Notice of Modification

The project approval (09_0182) for the Boggabri Coal Project, granted by the Planning Assessment Commission under delegation from the Minister for Planning and Infrastructure on 18 July 2012.

Figure 4: Additional Infrastructure Mod 4

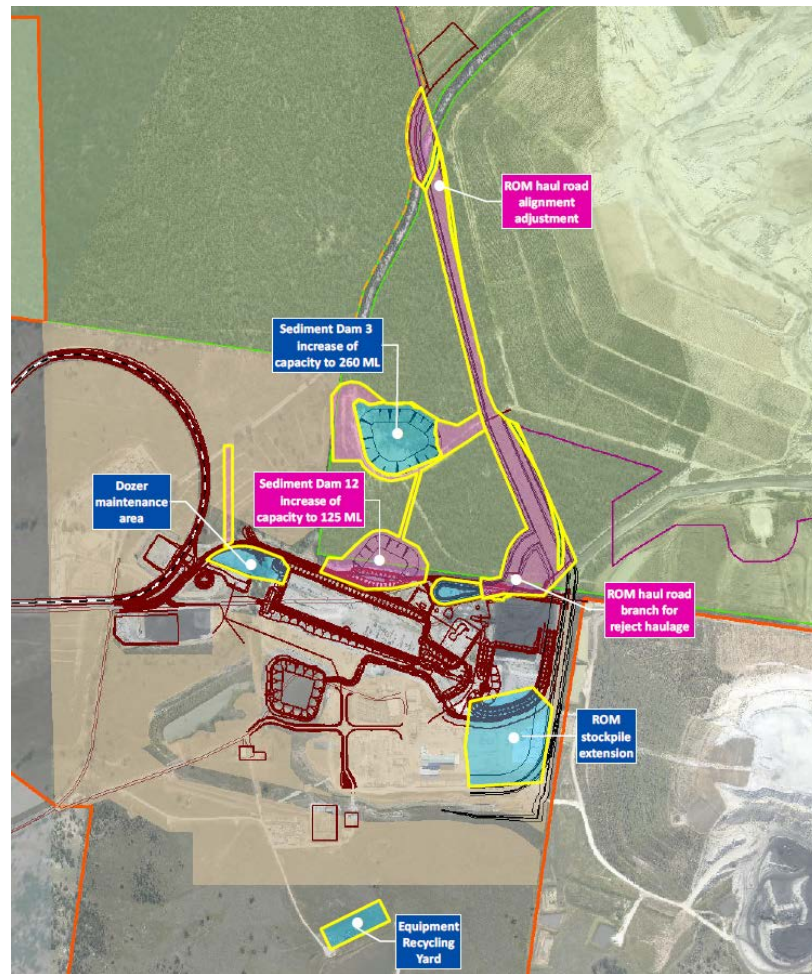
9. In Appendix 2 Project Layout Plan insert the following figure after Figure 3.

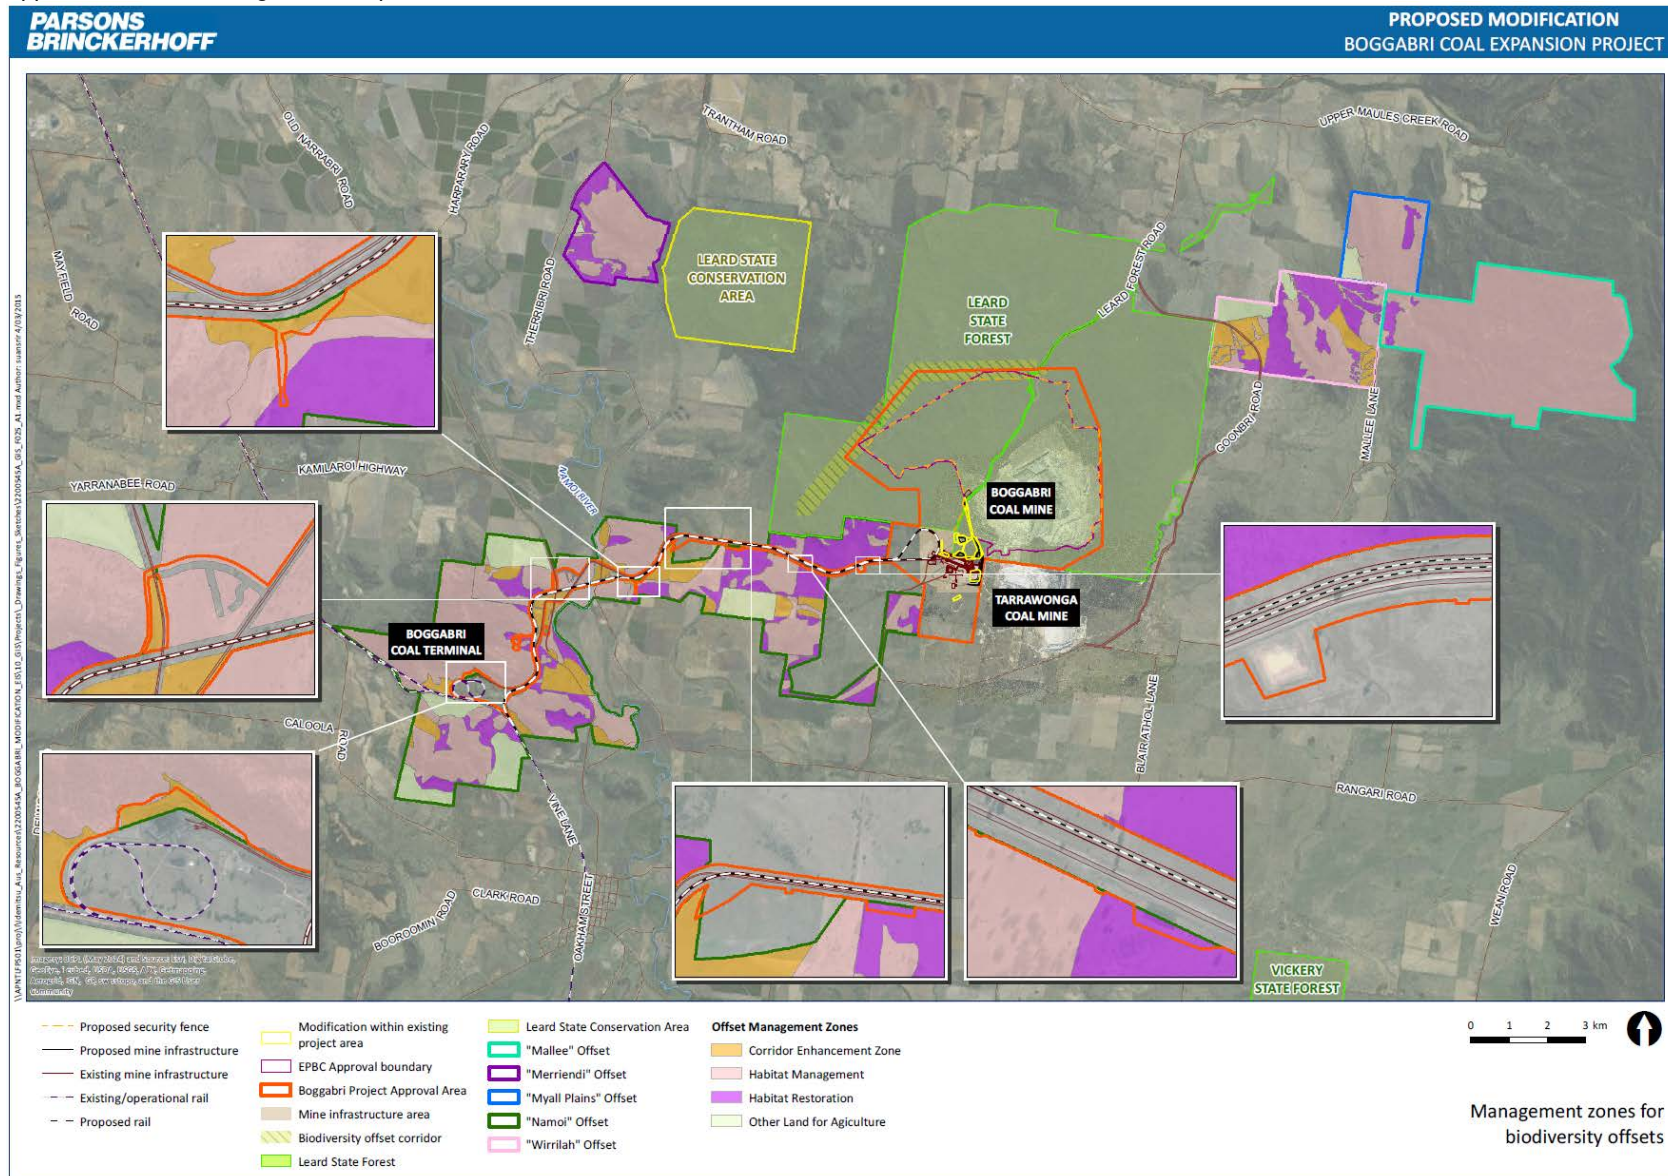
10. In Appendix 7 delete the figure and replace with:
